Application by Highways England for a Development Consent Order in relation to the A585 Windy Harbour to Skippool Improvement Scheme

The Examining Authority's written questions and requests for information (ExQ1)

Issued on 16 April 2019

Figure 1-1: Existing Culvert Plan View

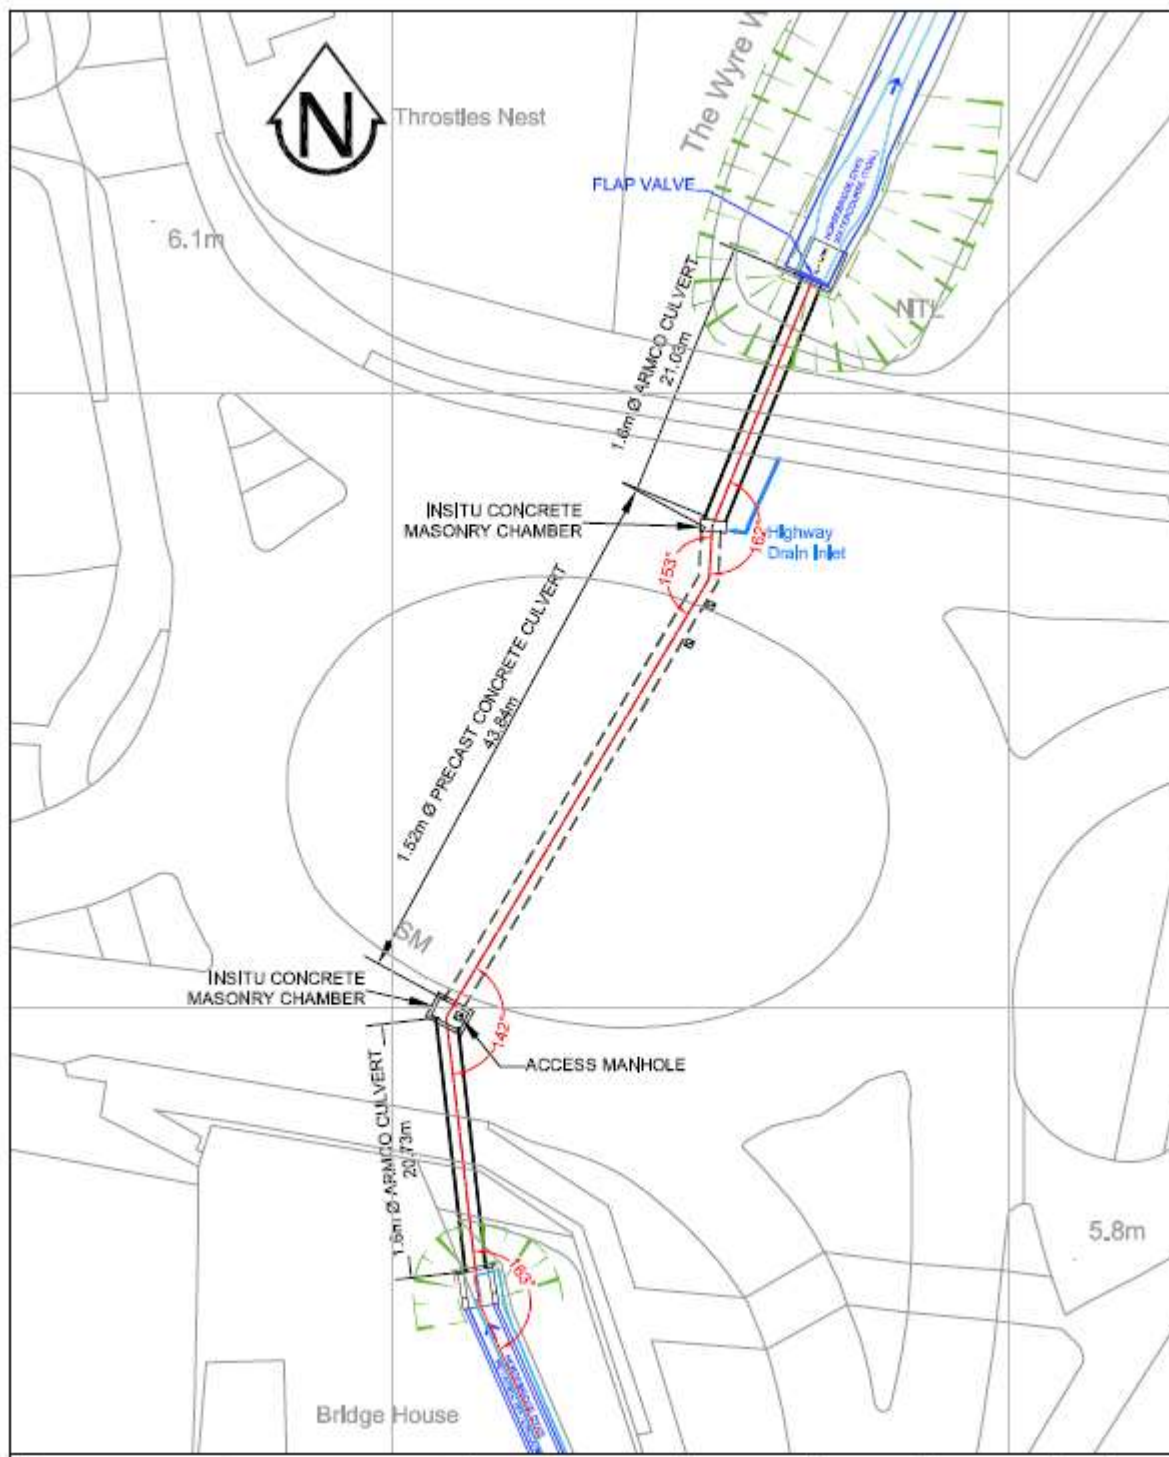
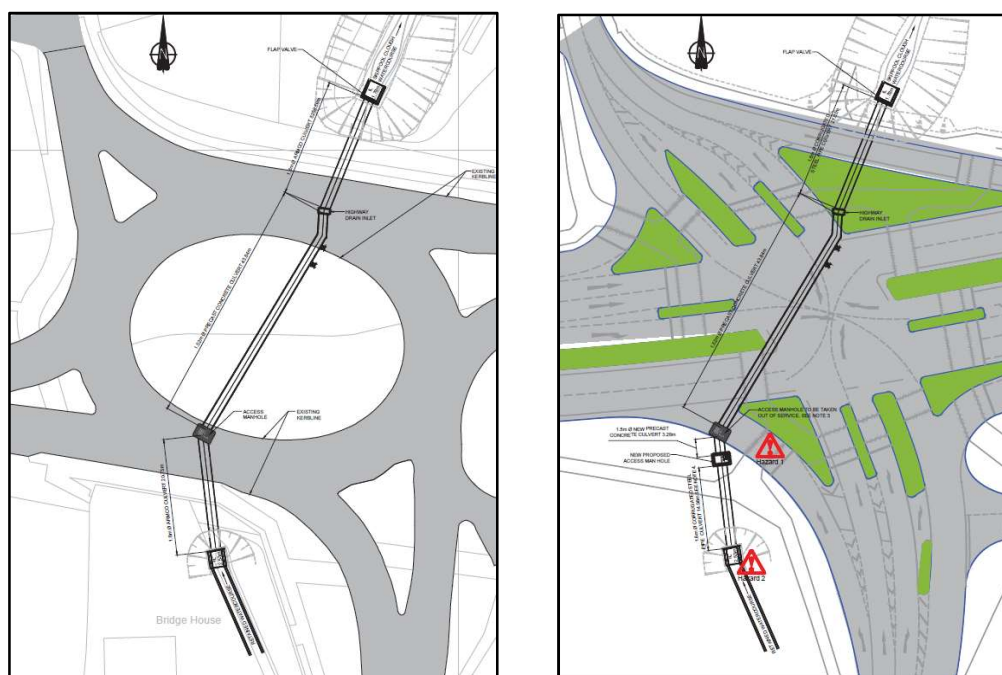
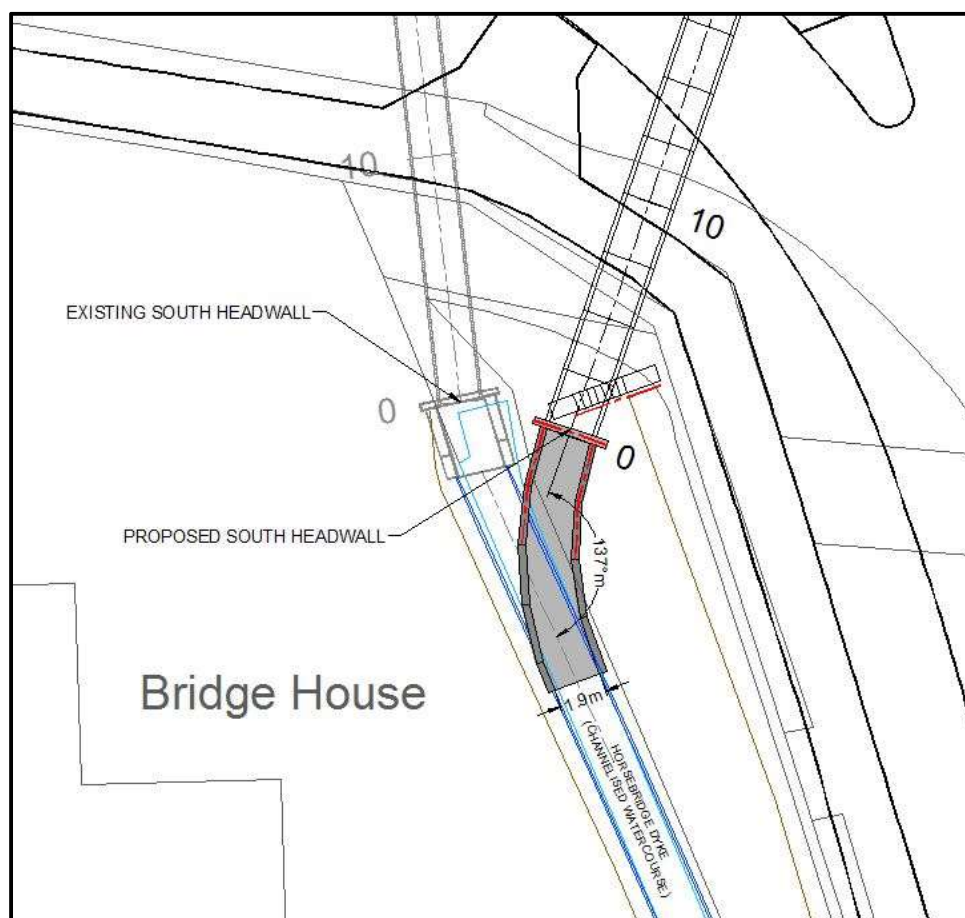
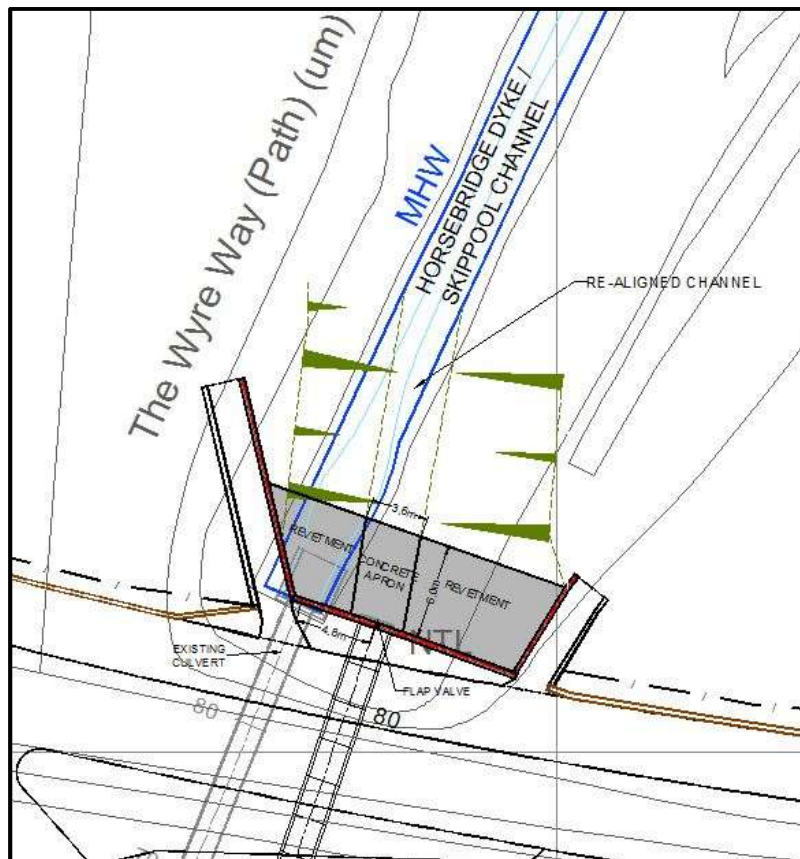
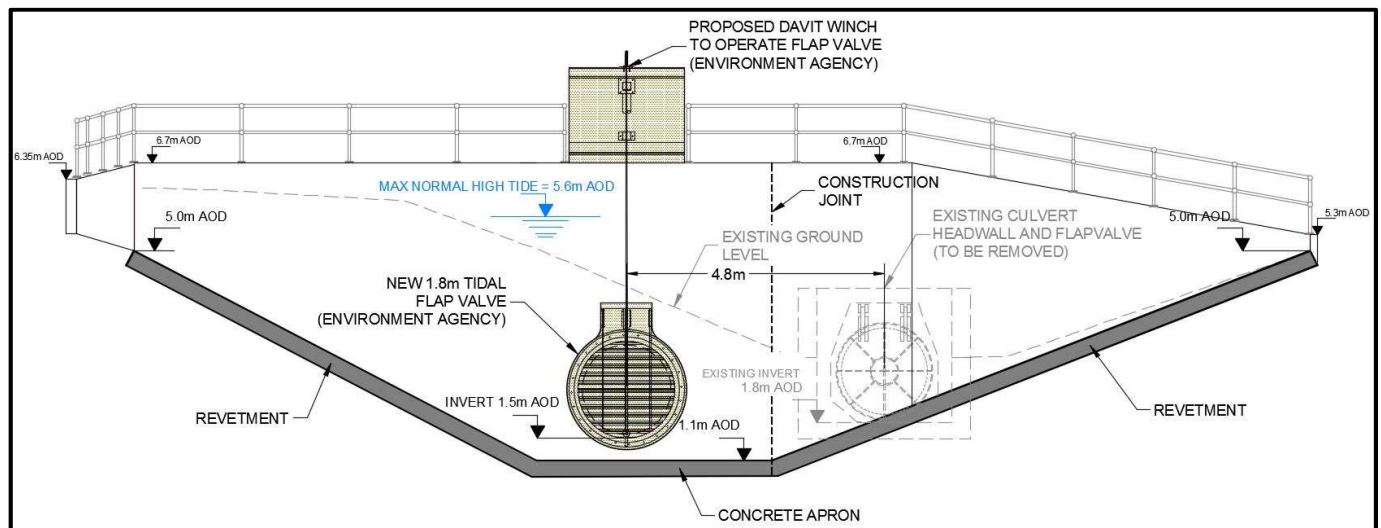
1.7.3.	The Applicant	Replacement Culverts Can the Applicant confirm the design of the replacement Horsebridge Dyke culvert and illustrate the effectiveness of this mitigation measure for water quality during construction and for flood risk during operation?
